From: Juan Baeza
Sent: 30 August 2017 10:10
To: Planning.Responses
Subject: FW: A/87/17/L & A/88/17/HH - The Old Cottage, Station Road, Angmering BN16 4HY

From: Ian Wightman [REDACTED]
Sent: 22 August 2017 12:34
To: Russell McCourty
Cc: David Easton; Juan Baeza; Mark Jones; John Hinds; Liz Galloway; Emma Weaver
Subject: RE: A/87/17/L & A/88/17/HH - The Old Cottage, Station Road, Angmering BN16 4HY

SIDE ELEVATION SOUTH

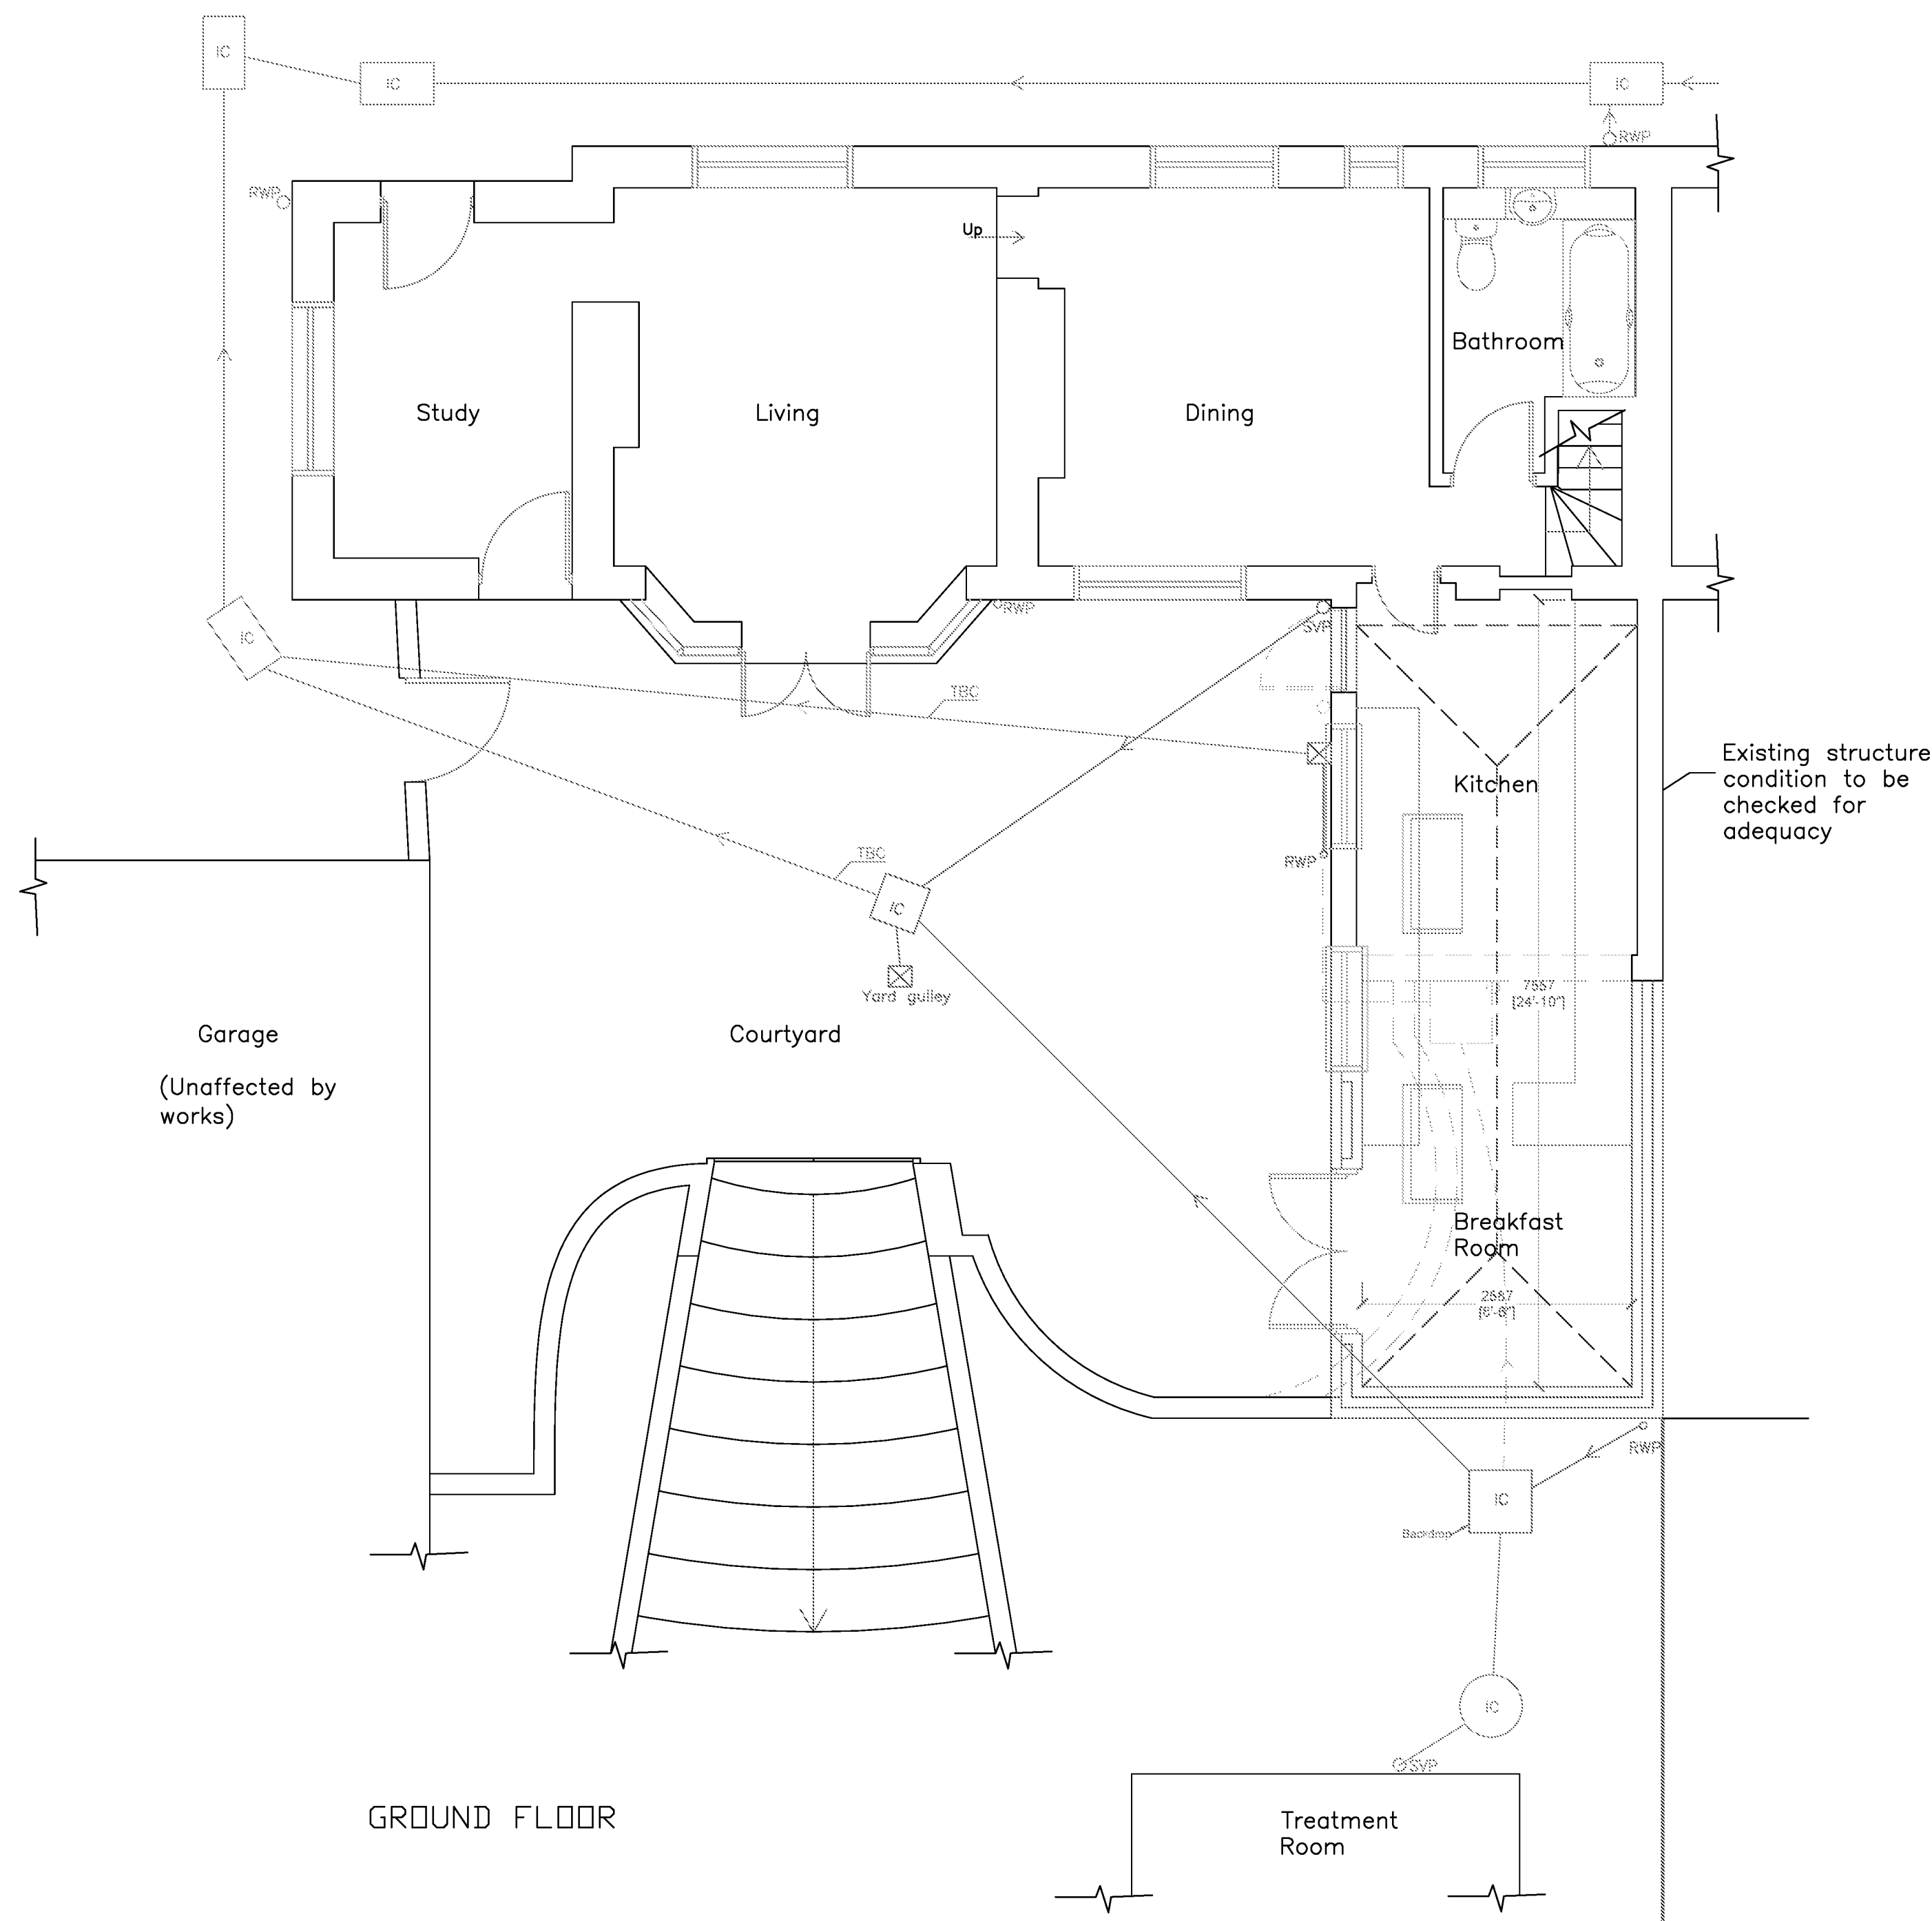
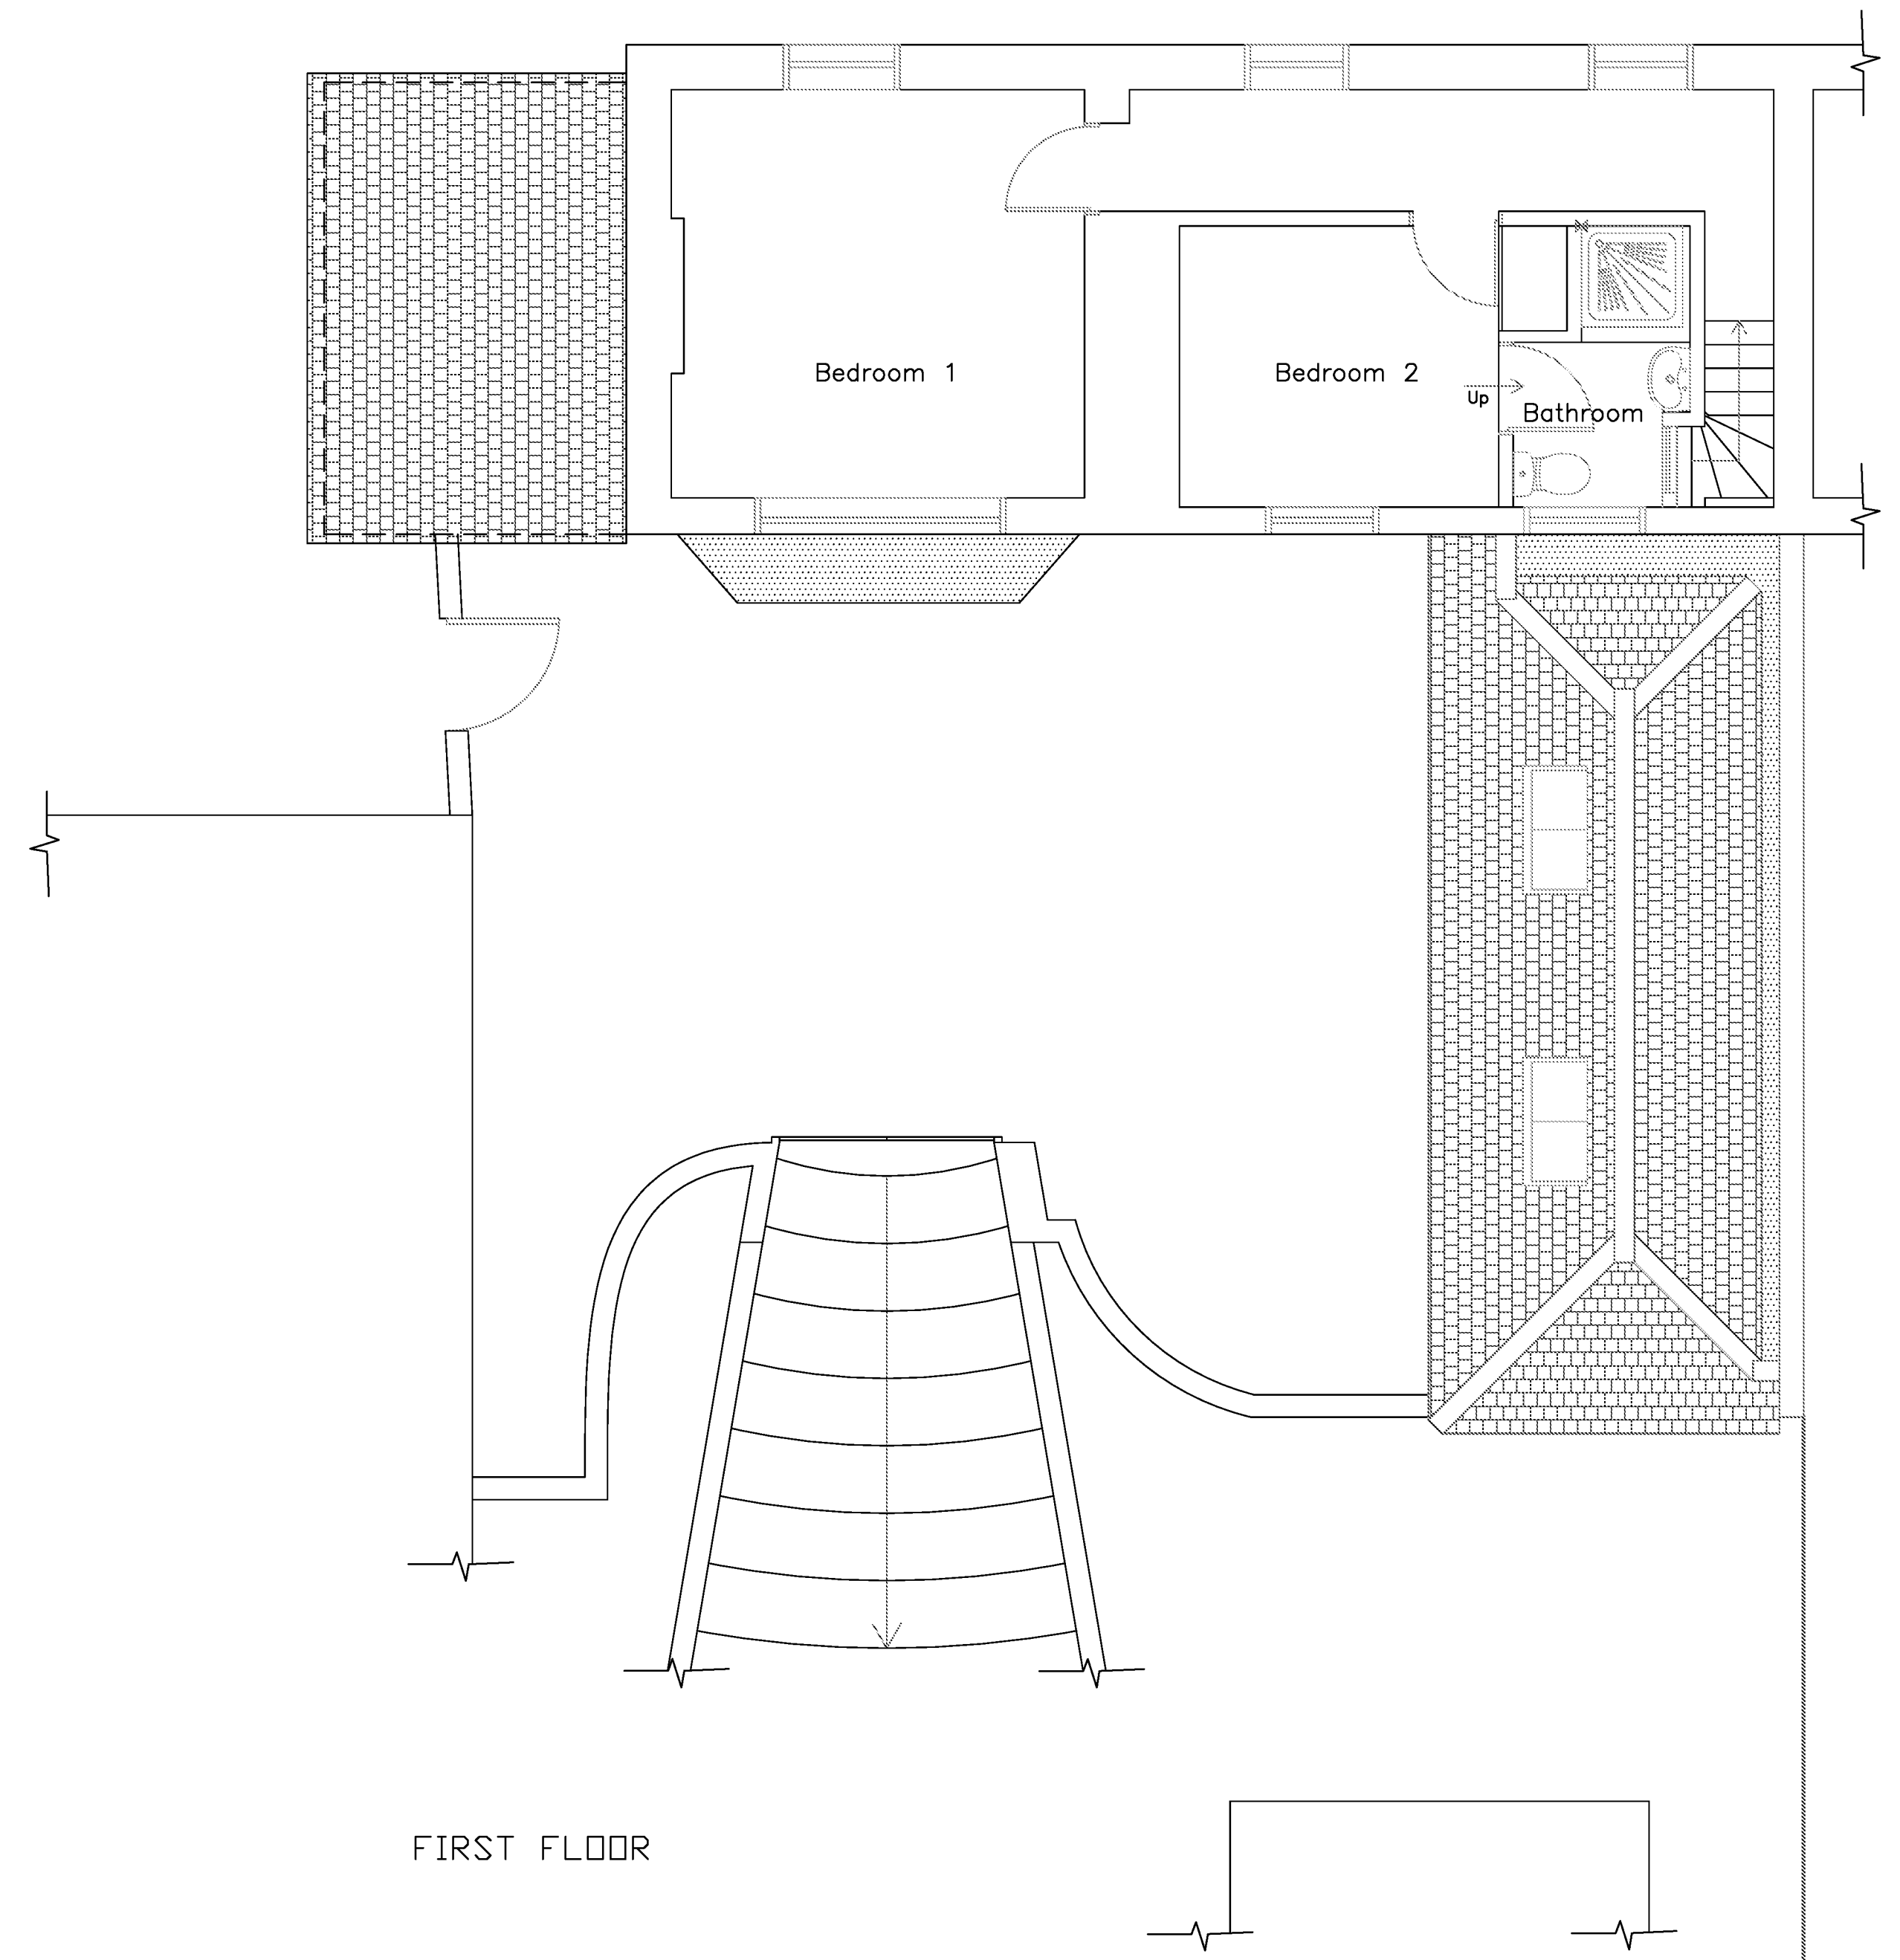
Thank you for the revised drawings showing amendments to the extension. Given the improvements to the south elevation we are now in a position to support this design.

We will require a condition for the brickwork and to this end you might want to consider Flemish or English bond which will add some interest without being too complicated.
